3.4 CHILD CARE FITOUT

3.5 BUILDING HEIGHT

## SICEEP - Darling Square Shadow Study

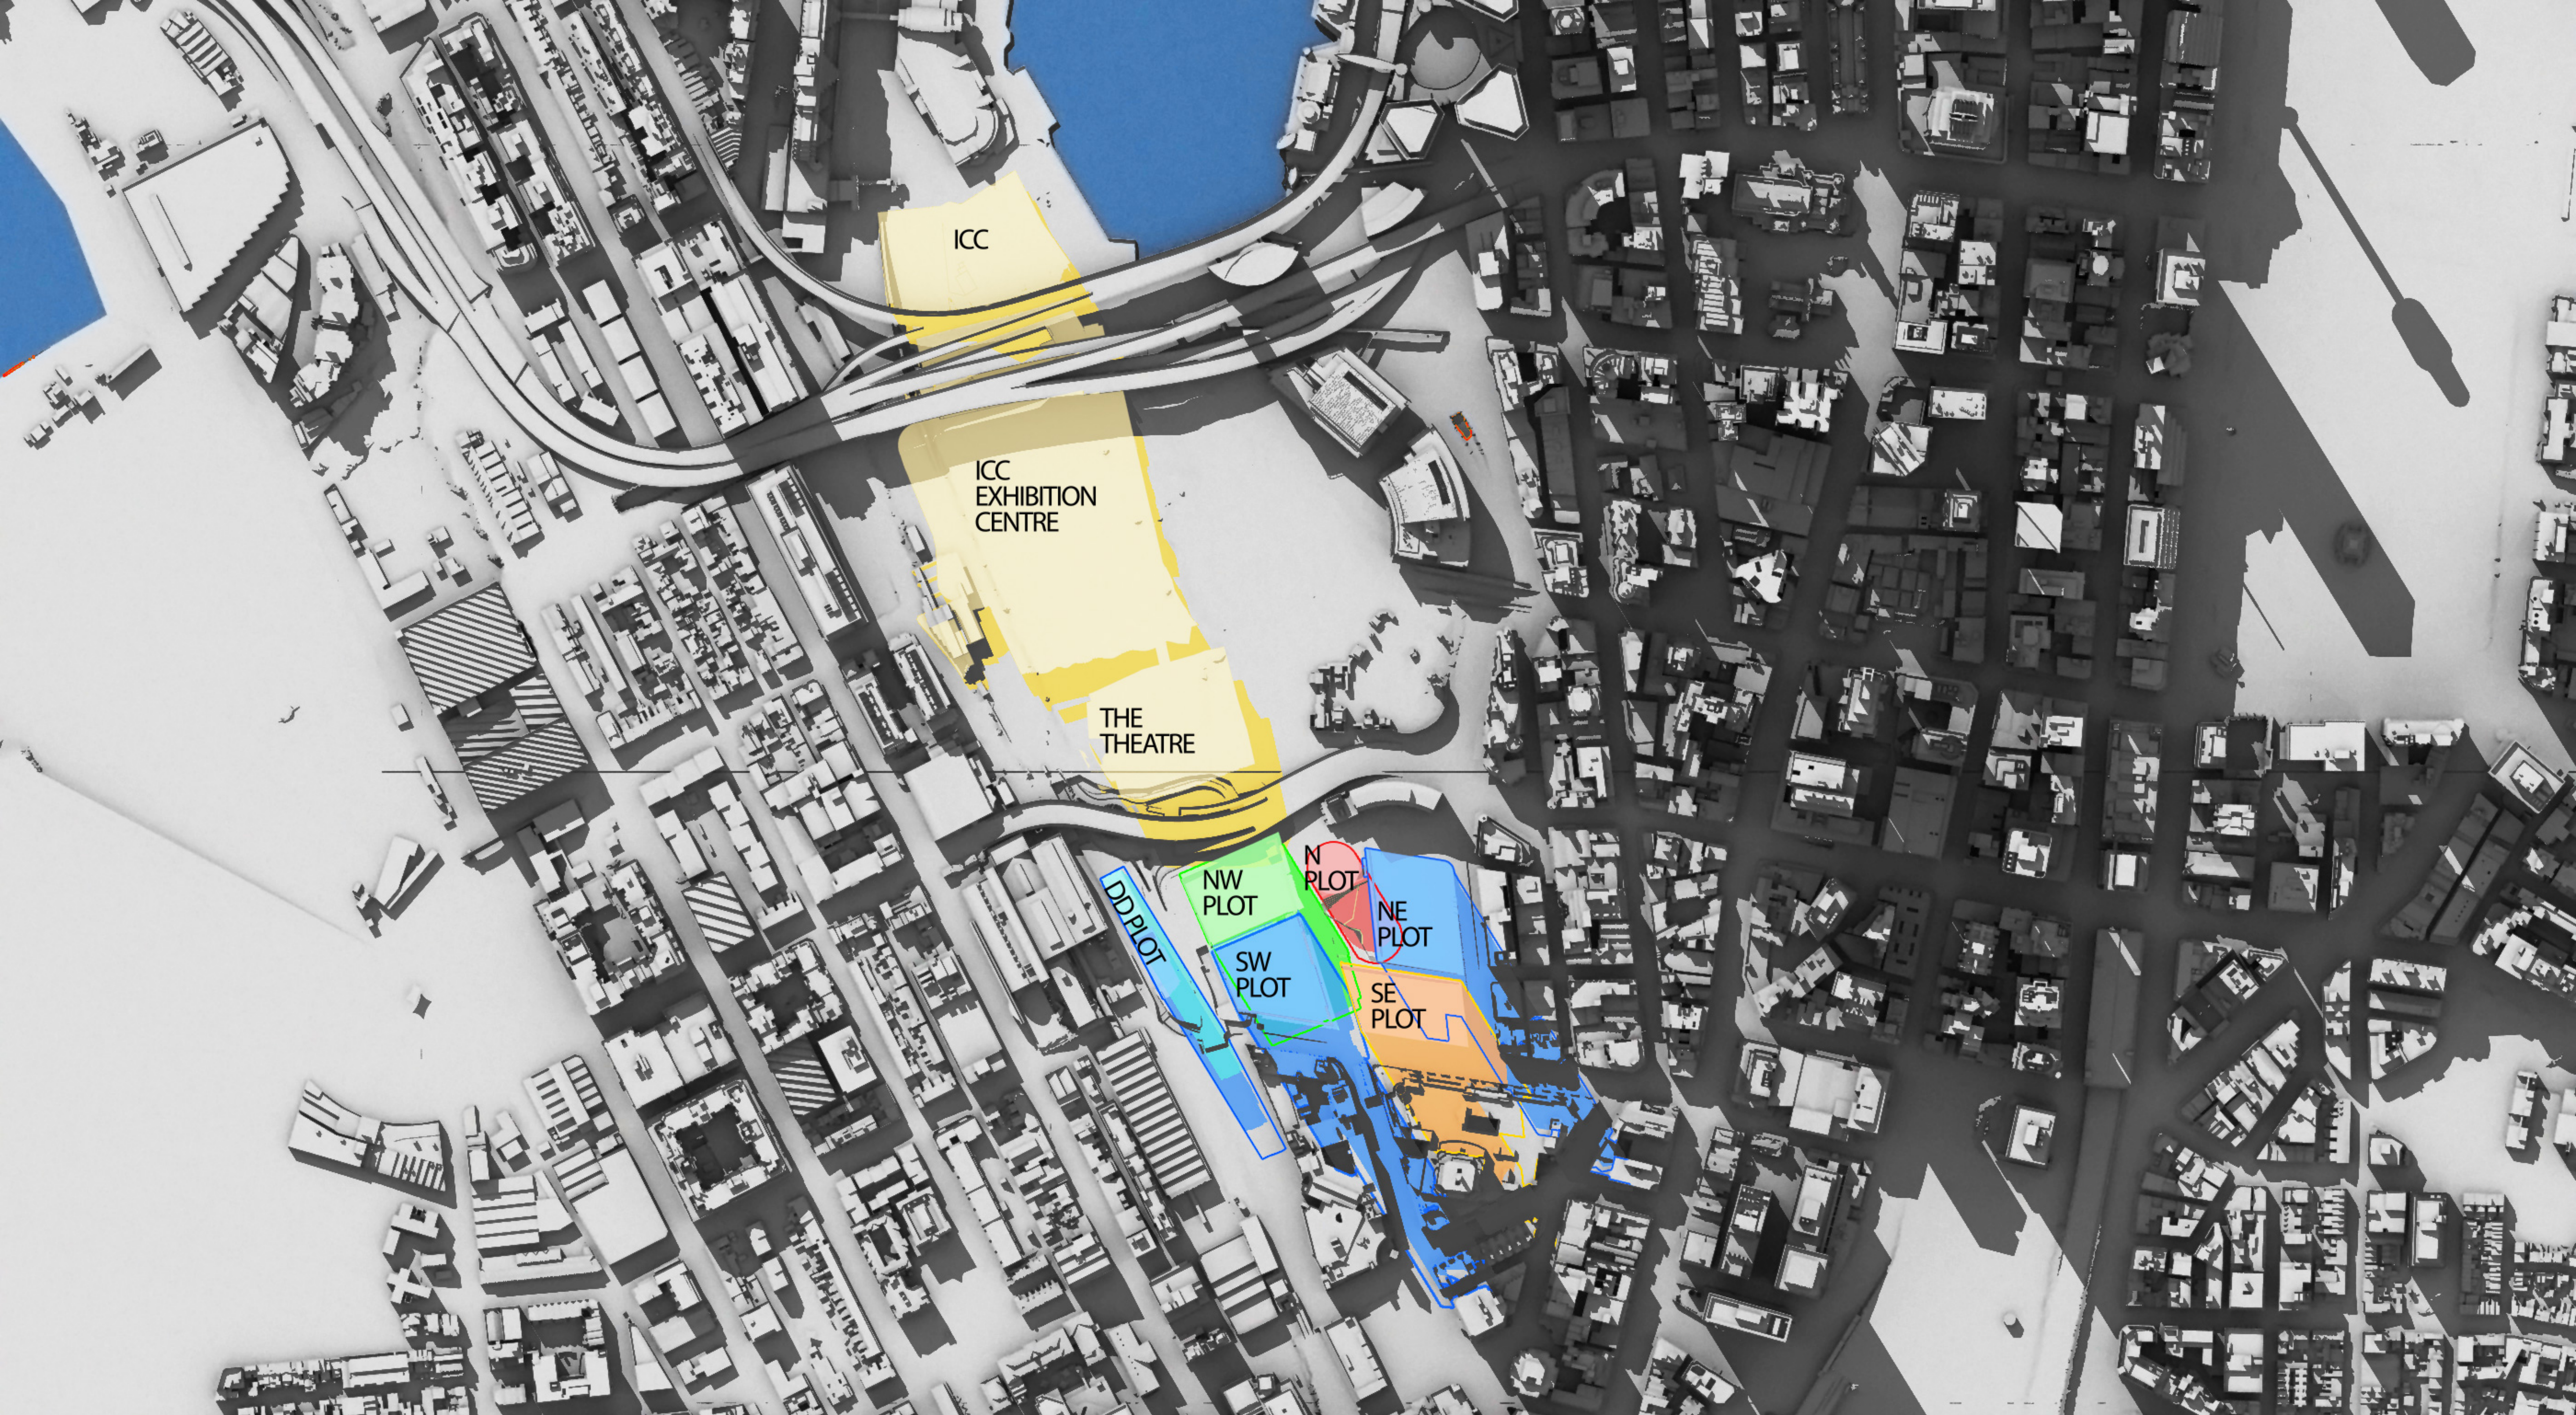
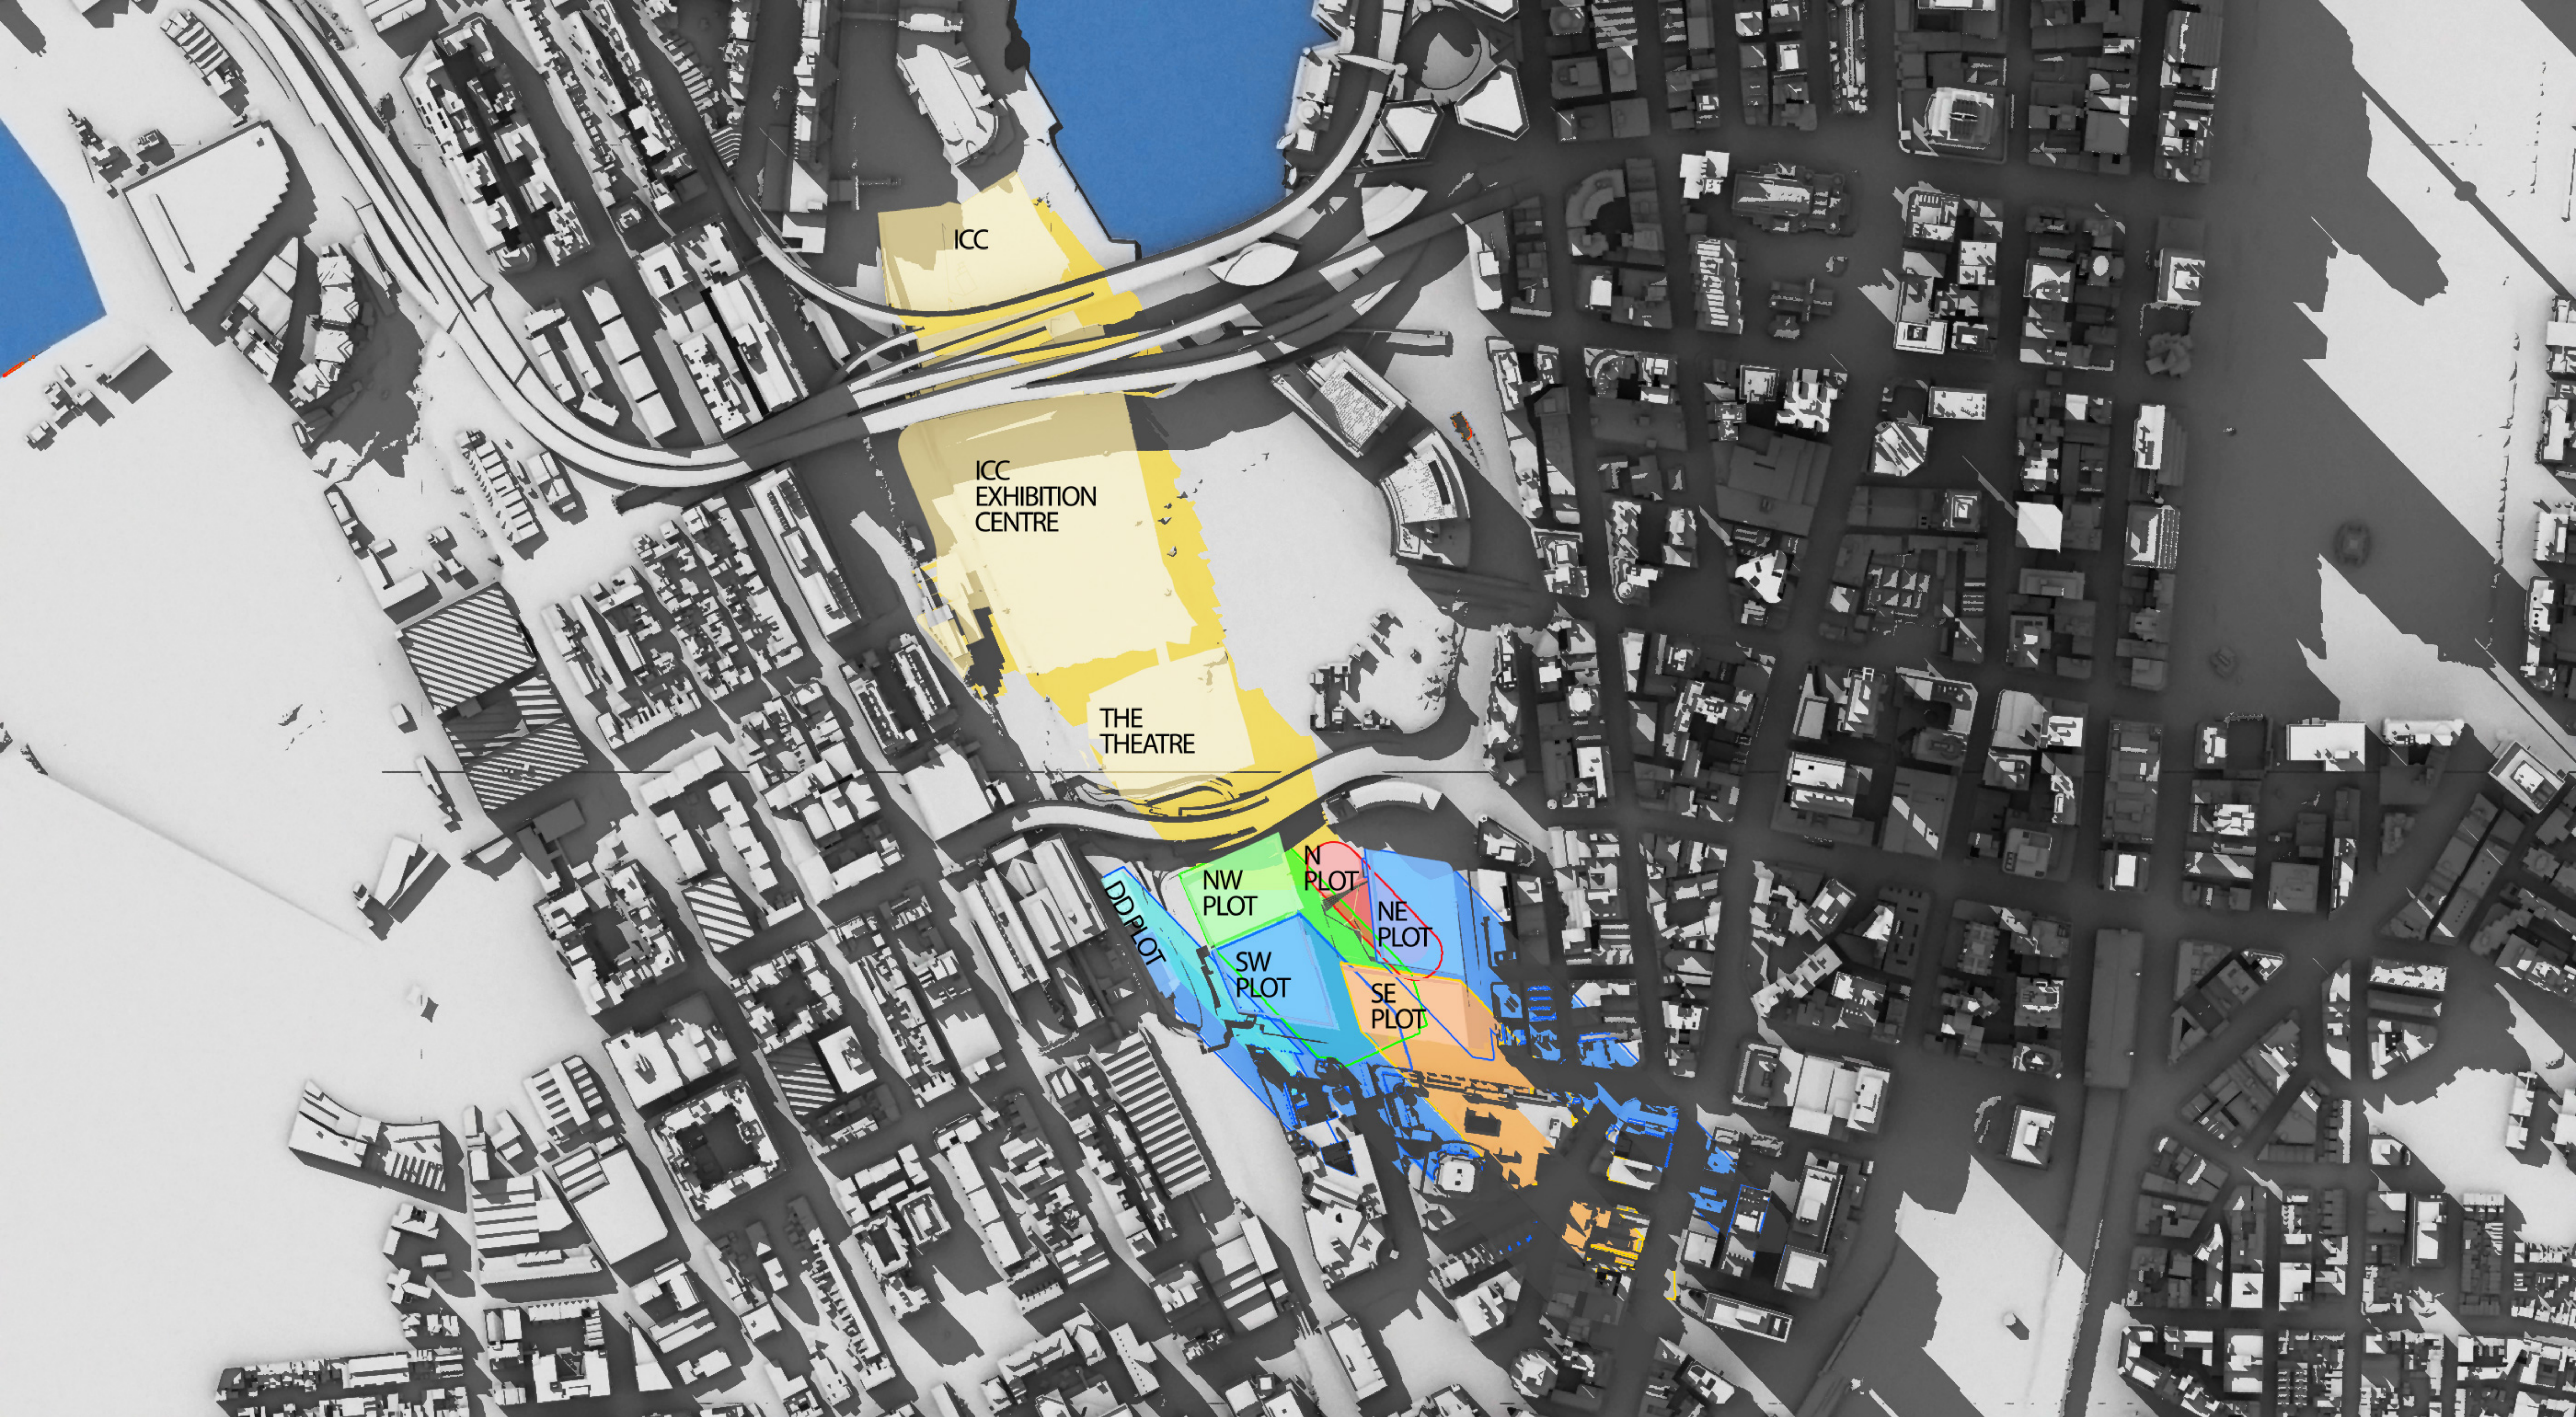
The Authority notes that the height of the proposed building (Darling Exchange) on the North Plot has increased by 5 metres. Any increase in building height should not create additional overshadowing across Haymarket Square during mid-winter. Further modelling is considered necessary in order to ensure solar access across Haymarket Square is maximised, especially the critical 12 midday to 2.00pm lunch time period during mid-winter and to confirm that the built form of the Darling Exchange does not dominate the public square.

The impact from the 5m increase in height has been assessed in great detail as part of the S96 modification to the Concept Plan which has now been approved. The building is entirely within this parameter plan and consistent with the overall parameter plan height control.

The building has been positioned to minimise the shadowing throughout the year. Refer to Appendix B - Shadow Analysis for further information.
